CITY OF ALBUQUERQUE

April 16, 2021

Re: TI Glaz-Teck Industries
6700 Bluewater Rd NW
Traffic Circulation Layout
Architect's Stamp 04-15-2021 (K10-D062)

TRAFFIC CIRCULATION LAYOUT

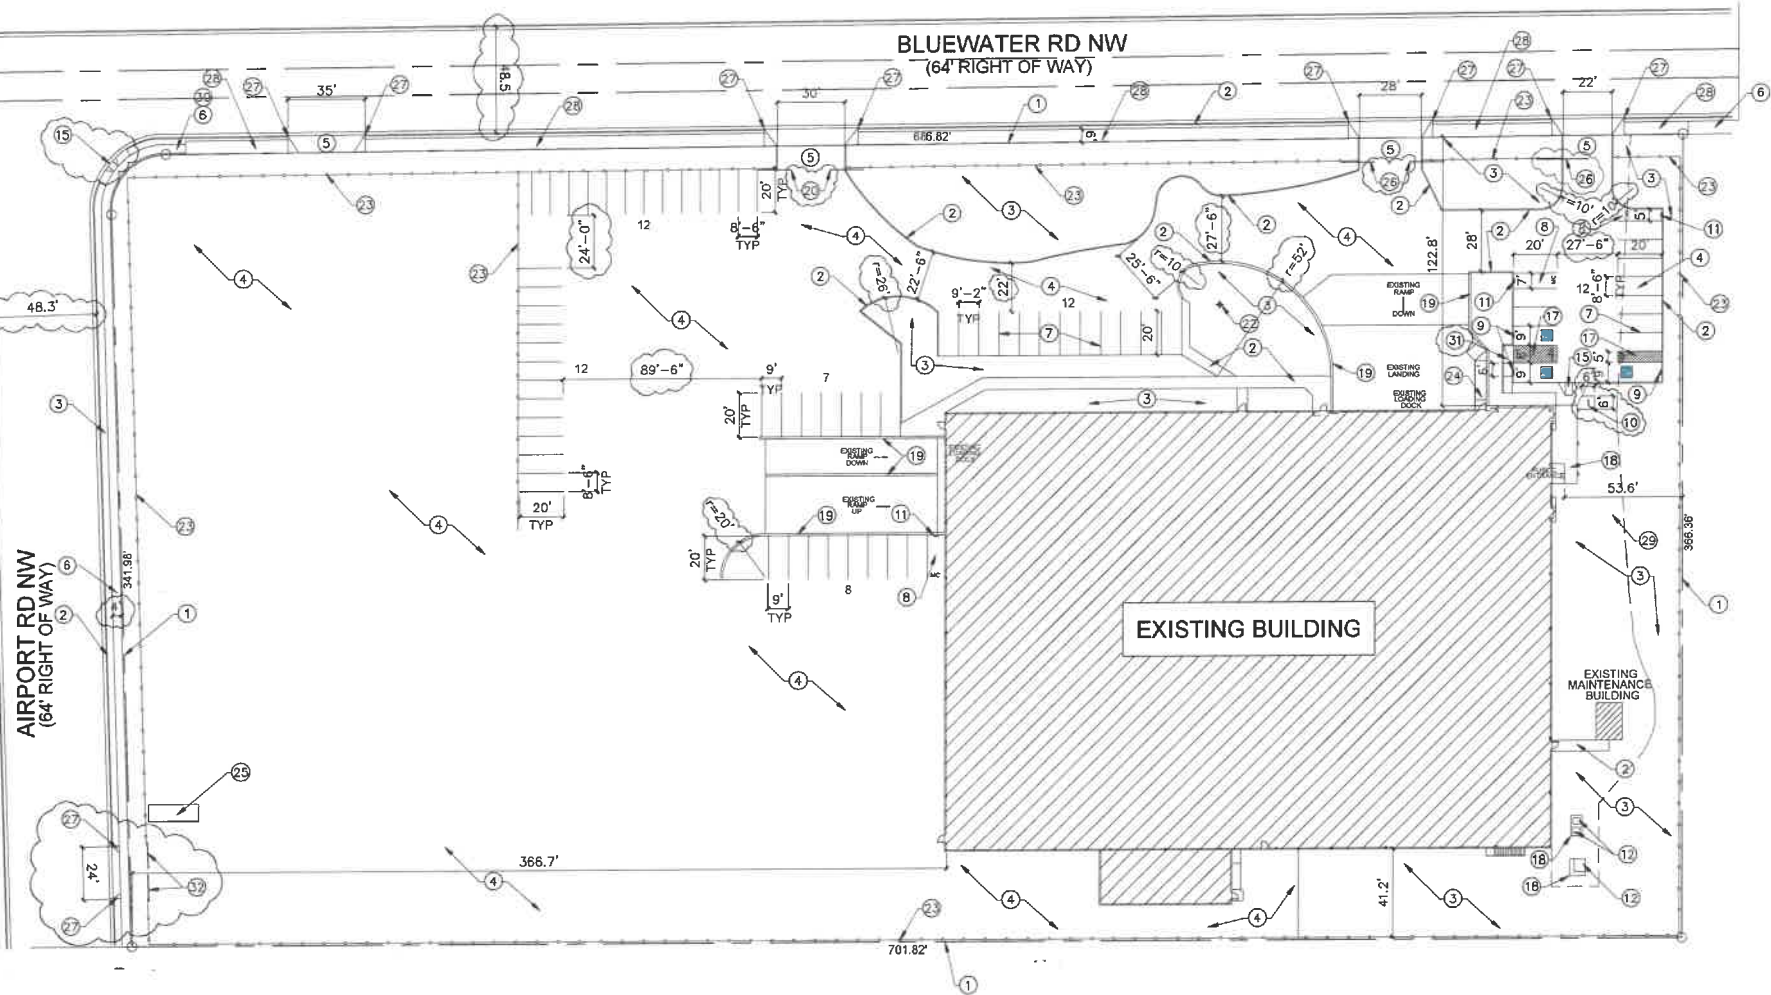
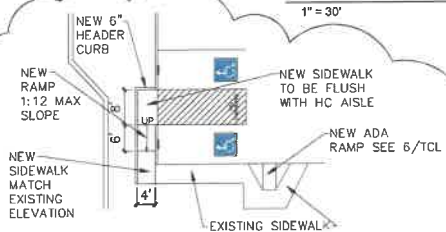
1. List the number of parking spaces required by the IDO as well as the proposed number of parking spaces including bicycle and motorcycle parking and **discuss with Zoning**.

2. Identify the right of way width, medians, curb cuts, and **street widths** on Airport and Bluewater Road.
3. The ADA accessible spaces must include an access aisle. Van accessible aisles should be 8ft wide; all others should be 5ft wide.

4. The ADA accessible parking sign must have the required language per 66-7-352.4C NMSA 1978 **"Violators Are Subject to a Fine and/or Towing."** Please call out detail and location of signs.

10. Show all drive aisle widths. Some **dimensions are not shown**.
11. The **minimum drive aisle dimensions** are shown below

12. List radii for all curves shown; for passenger vehicles. **Radius for delivery trucks, fire trucks, etc. is 25 ft. or larger.**
13. **Per the IDO, a 6 ft. wide ADA accessible pedestrian pathway is required from the public sidewalk to the building entrances. Please clearly show this pathway and provide details.**

14. **Per DPM, a 6 ft. wide ADA accessible pedestrian pathway is required from the ADA parking stall access aisles to the building entrances.** Please clearly show this pathway and provide details. Provide a pathway from the 6ft wide ADA parking access aisle to the bldg. entrance.

15. **ADA accessible pedestrian pathway should not be placed behind parking space or adjacent to a vehicular way.** Vehicle and pedestrian/wheel chair conflicts should be avoided as much as possible.

7 **TCL** **NEW SIDEWALK & RAMP**
1" = 15'

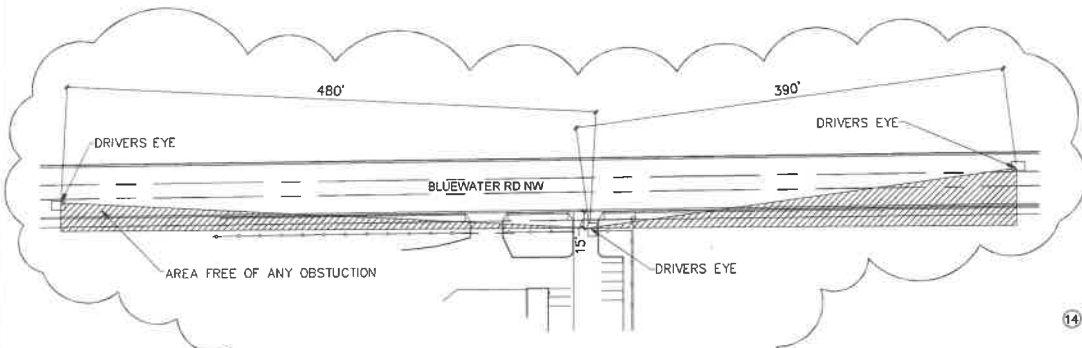
5. ADA curb ramps must be **updated to current standards (Verify)** and have **truncated domes installed** at the corner of Airport and Bluewater Road.

16. All sidewalks along Airport Road: Provide existing width and on Bluewater Road approaching corner ADA ramp need to show the width transitions from a wider to a smaller width (**coa std dwg 2432**).

17. **Key Note 30:** Reference coa std dwg 2431.
18. **Key Note 15:** Provide detail to ensure ADA requirements are met.
19. **Key Note 87:** Striping detail will need to be provided (**color of stripe and width**)
